PO/8/21/L

Peckhams Poling Street Poling BN18 9PT

Listed building consent for the renovation of stable block to create a single storey timber framed barn style building for home office use with lean-to extension

TITLE
Proposed
Floor Plans &
Elevations
Site Plan

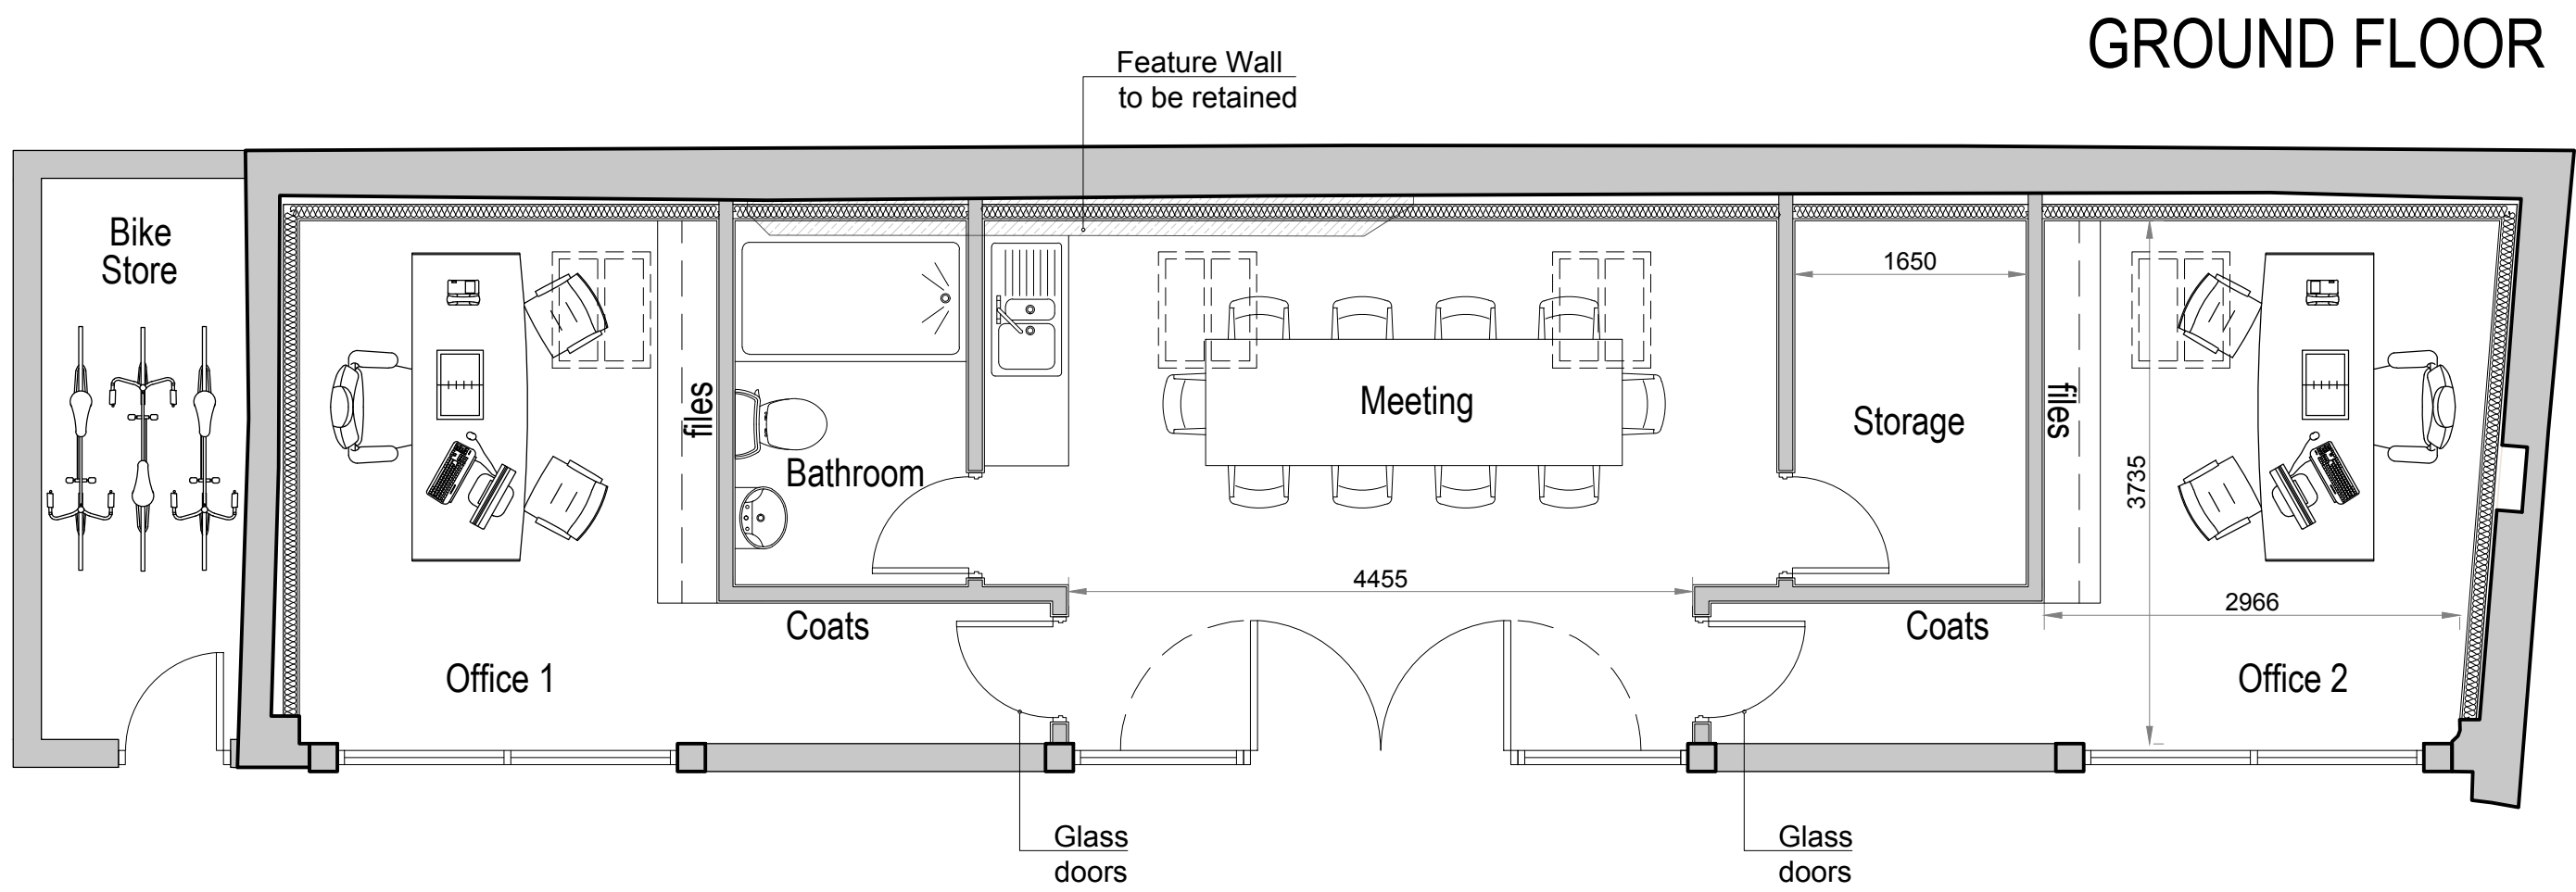
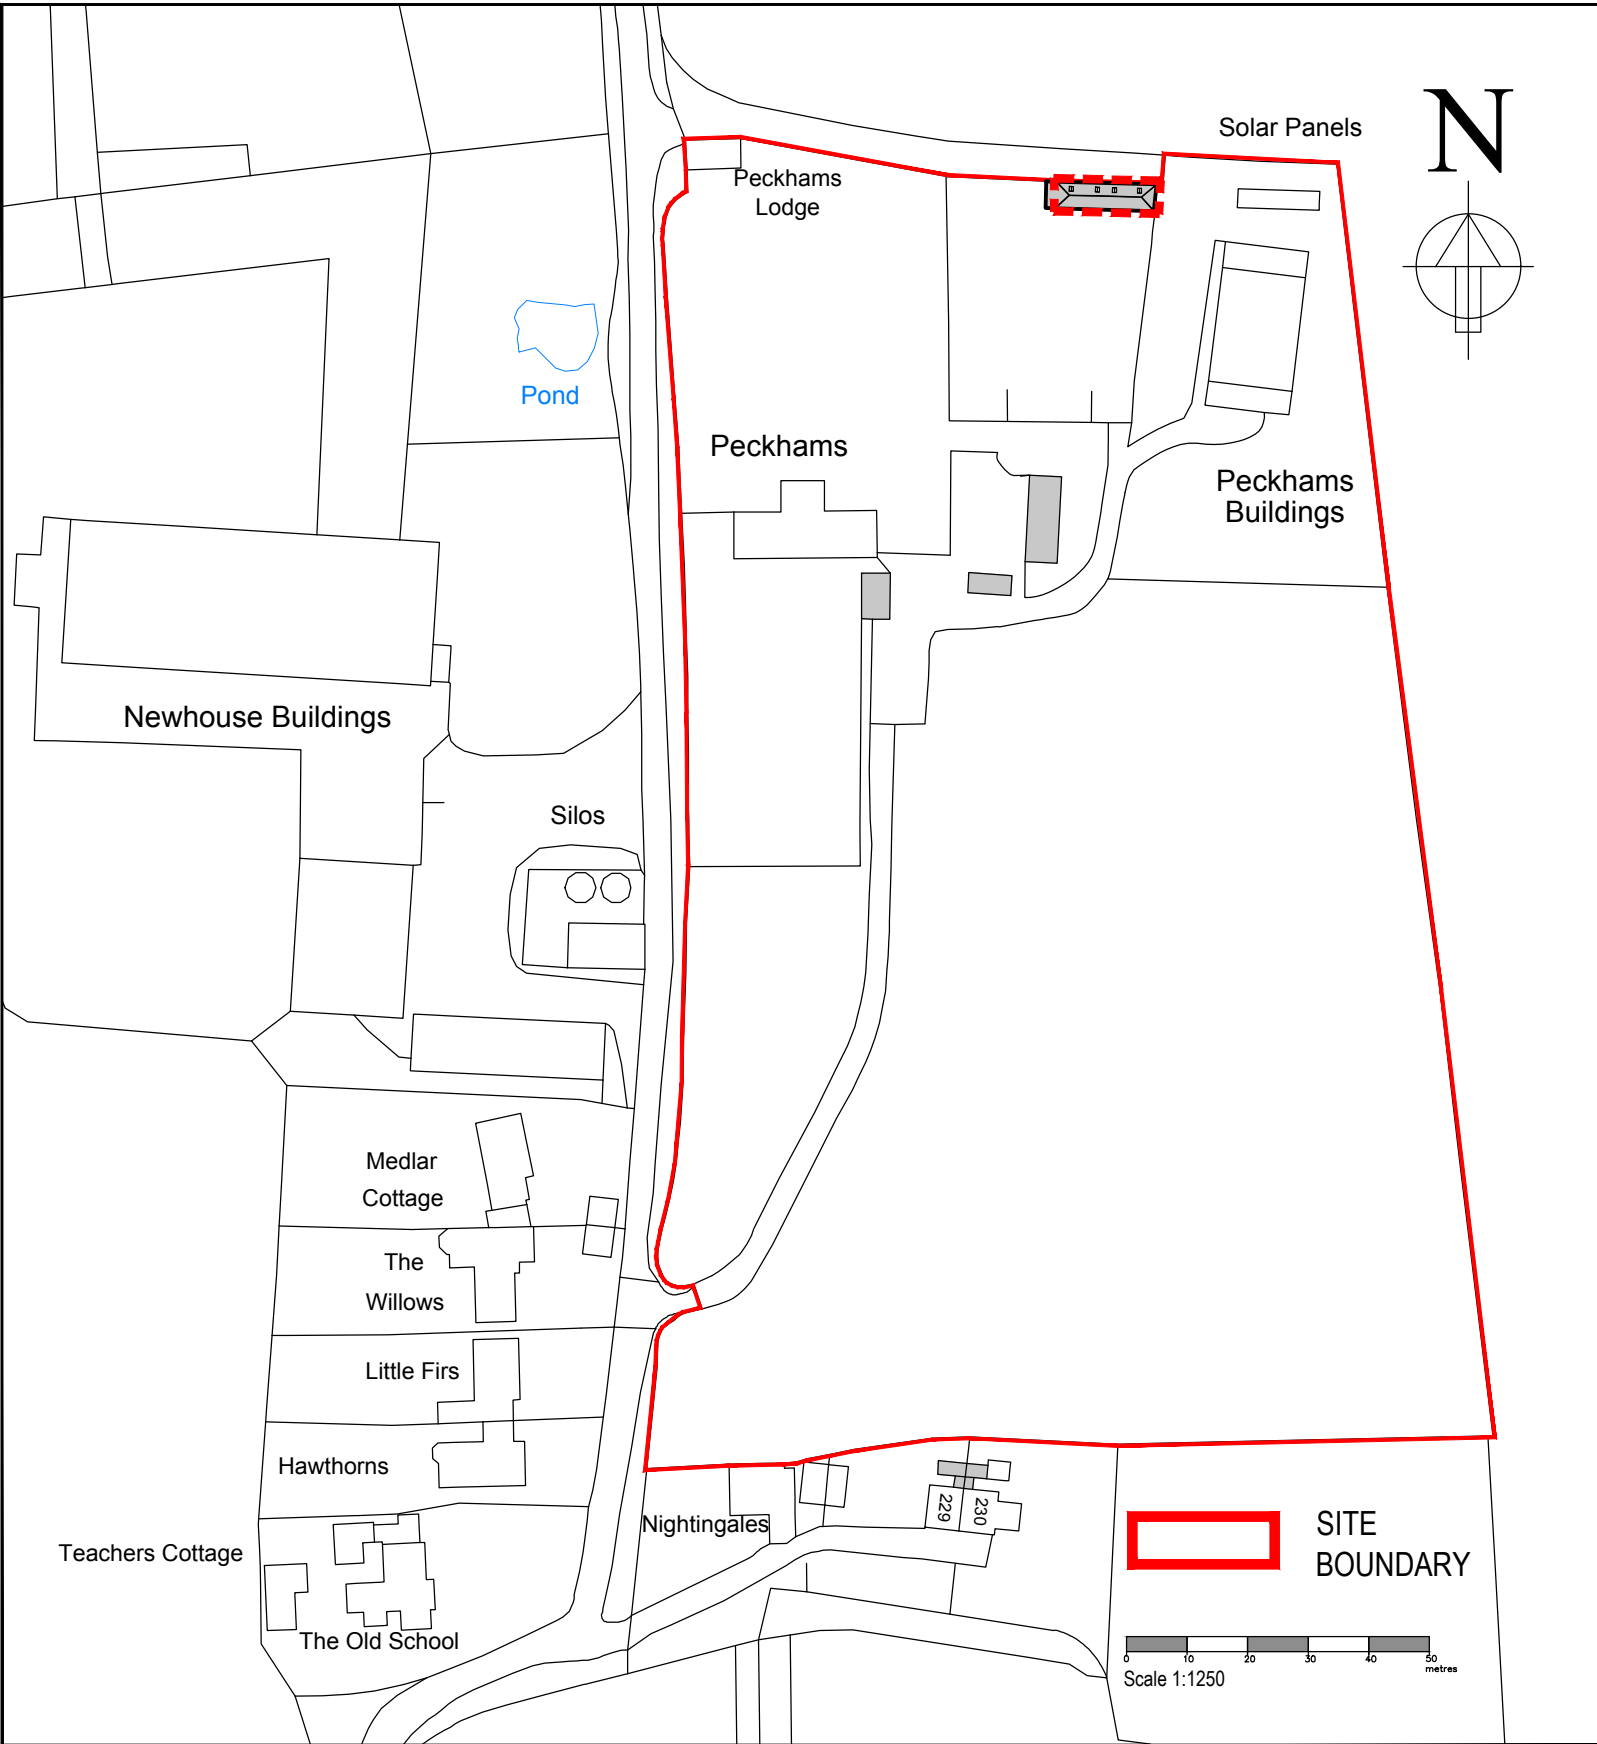
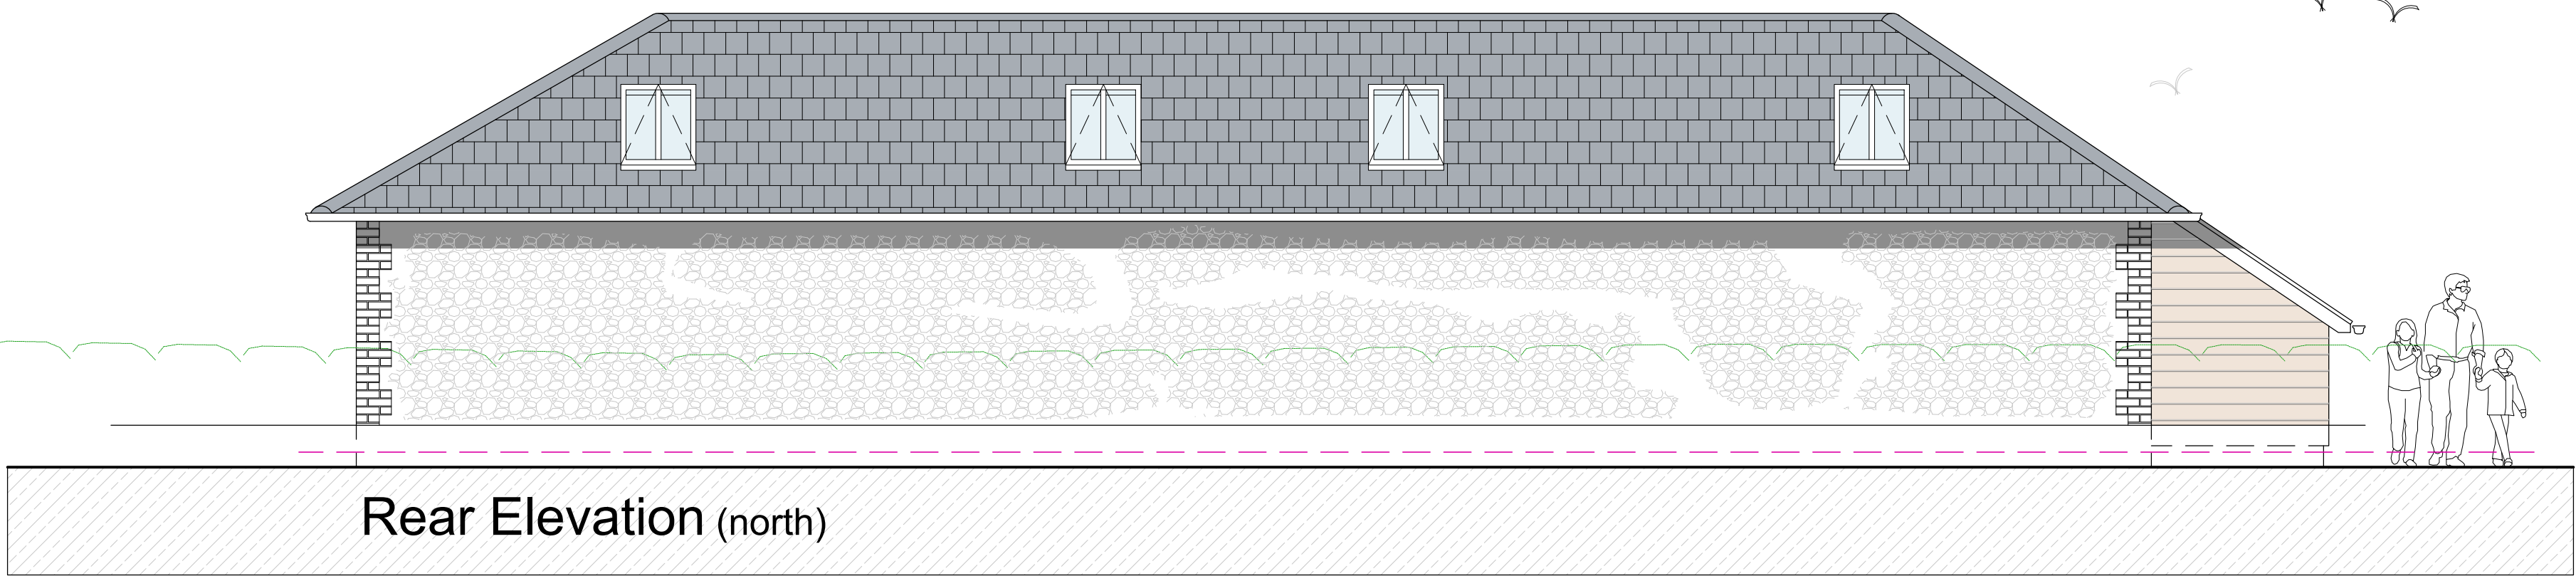
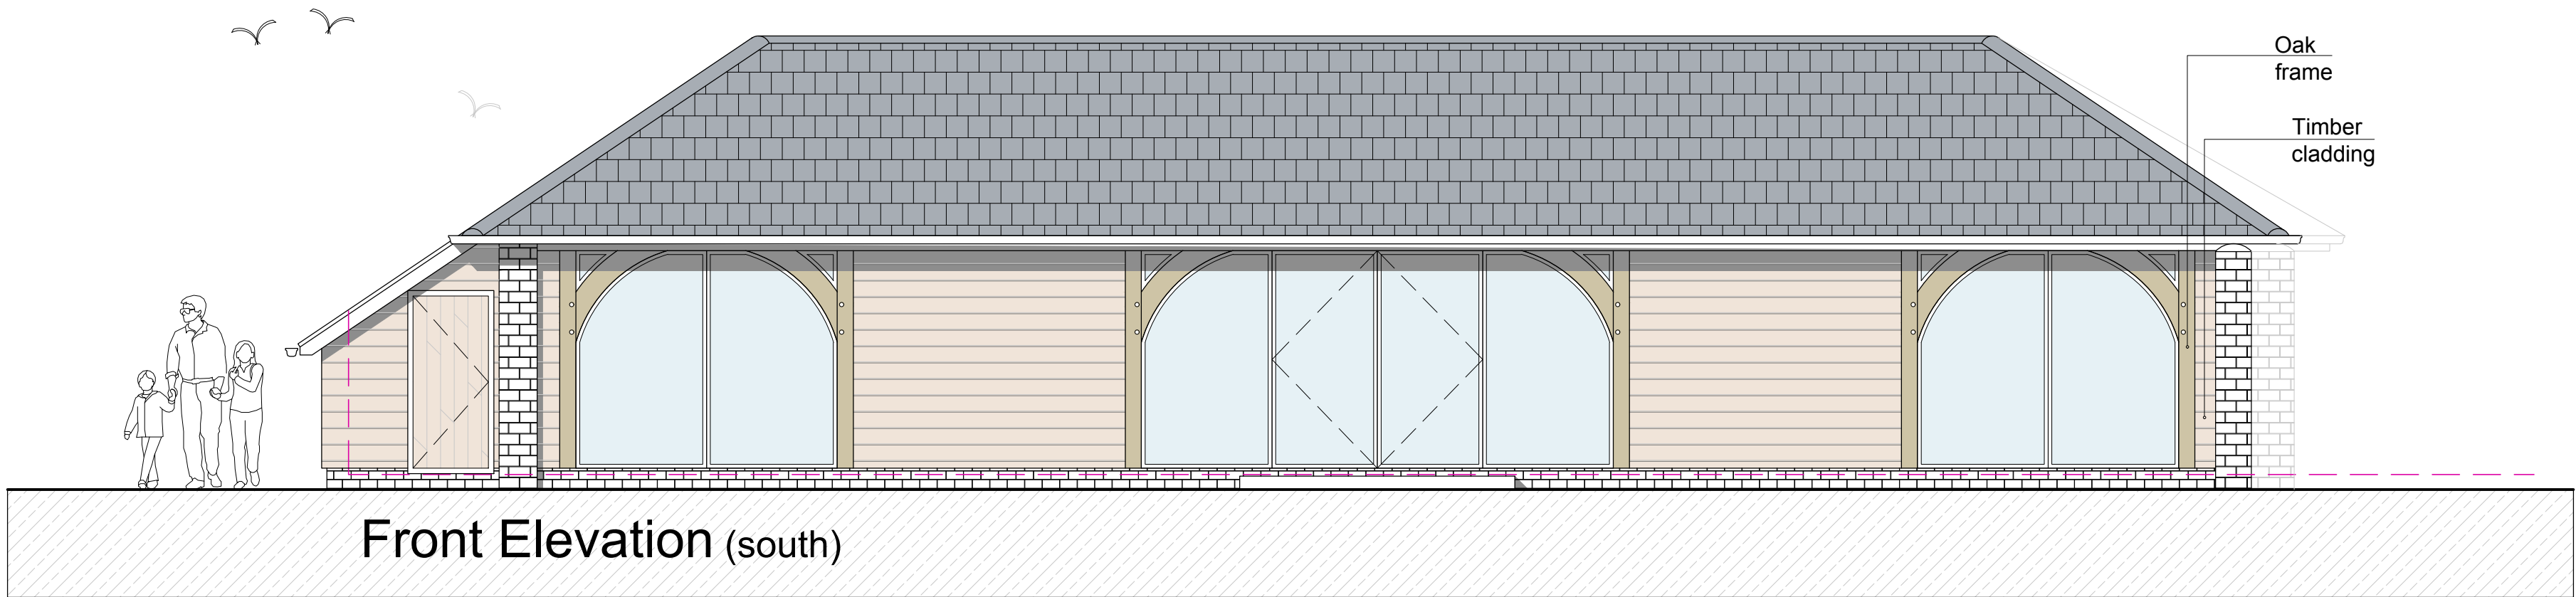
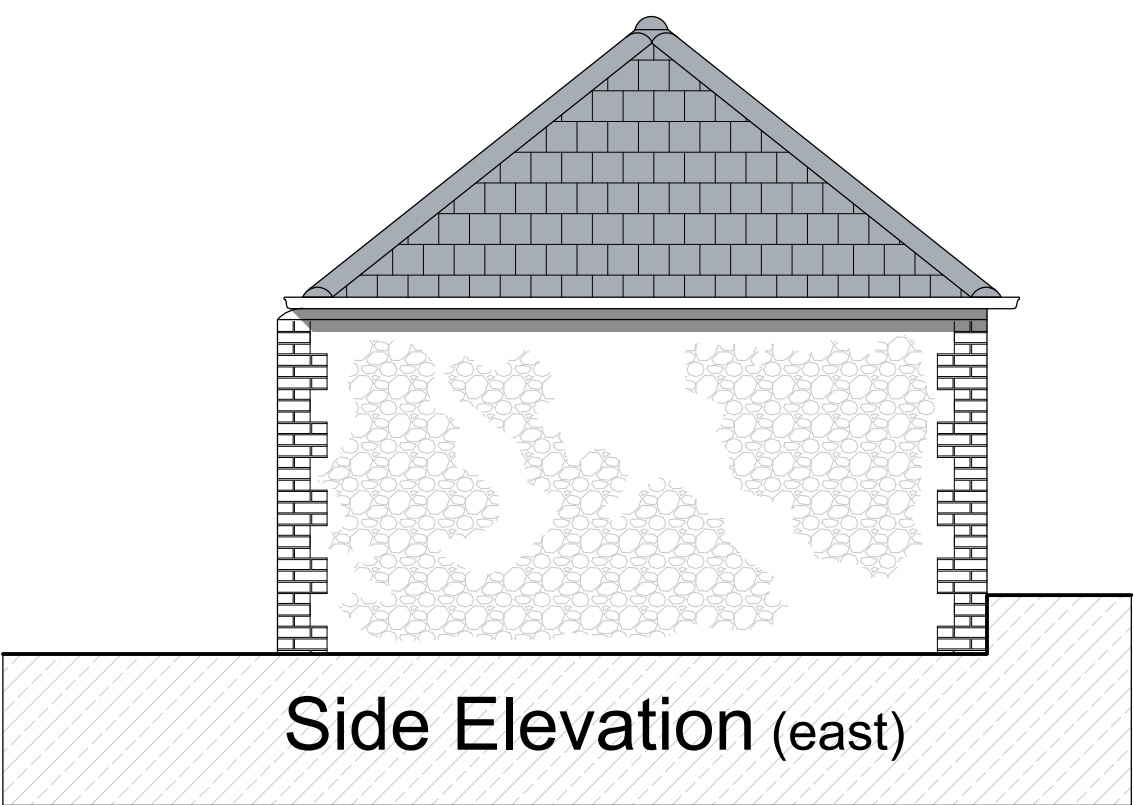
The proposed retention, refurbishment and re-use of the building is positive. It is also positive to see that the intention is for the front elevation to remain fairly simple in appearance with three openings. However, one of the statements associated with the application identifies that the timber frame to the front elevation is to be retained on show by the installation of timber panels or glazing between the framework rather than being covered up as currently exists. However, this is not clear if the existing ones will be relocated in order to accommodate the large central glazed area, nor if the existing staddle stones will be re-used. Please can this be confirmed. Also it would help to understand how the wood is to be treated, and further details of the windows/doors. Details of both of these can be provided for by way of condition, if you are minded to approve the application.

The proposed internal alterations appear to be reversible and are therefore acceptable. It would help to understand if the rooms are to be left open to the roof void. Such an approach ensures that the character of the existing space can be understood as opposed to the installation of modern ceilings, which is a feature not associated with agricultural buildings such as this. This also needs to be confirmed.

The addition of the bike store is carefully considered and will not harm the significance of the structure. My suggestion would be that the former external wall is left untreated so that it can still be seen/understood.
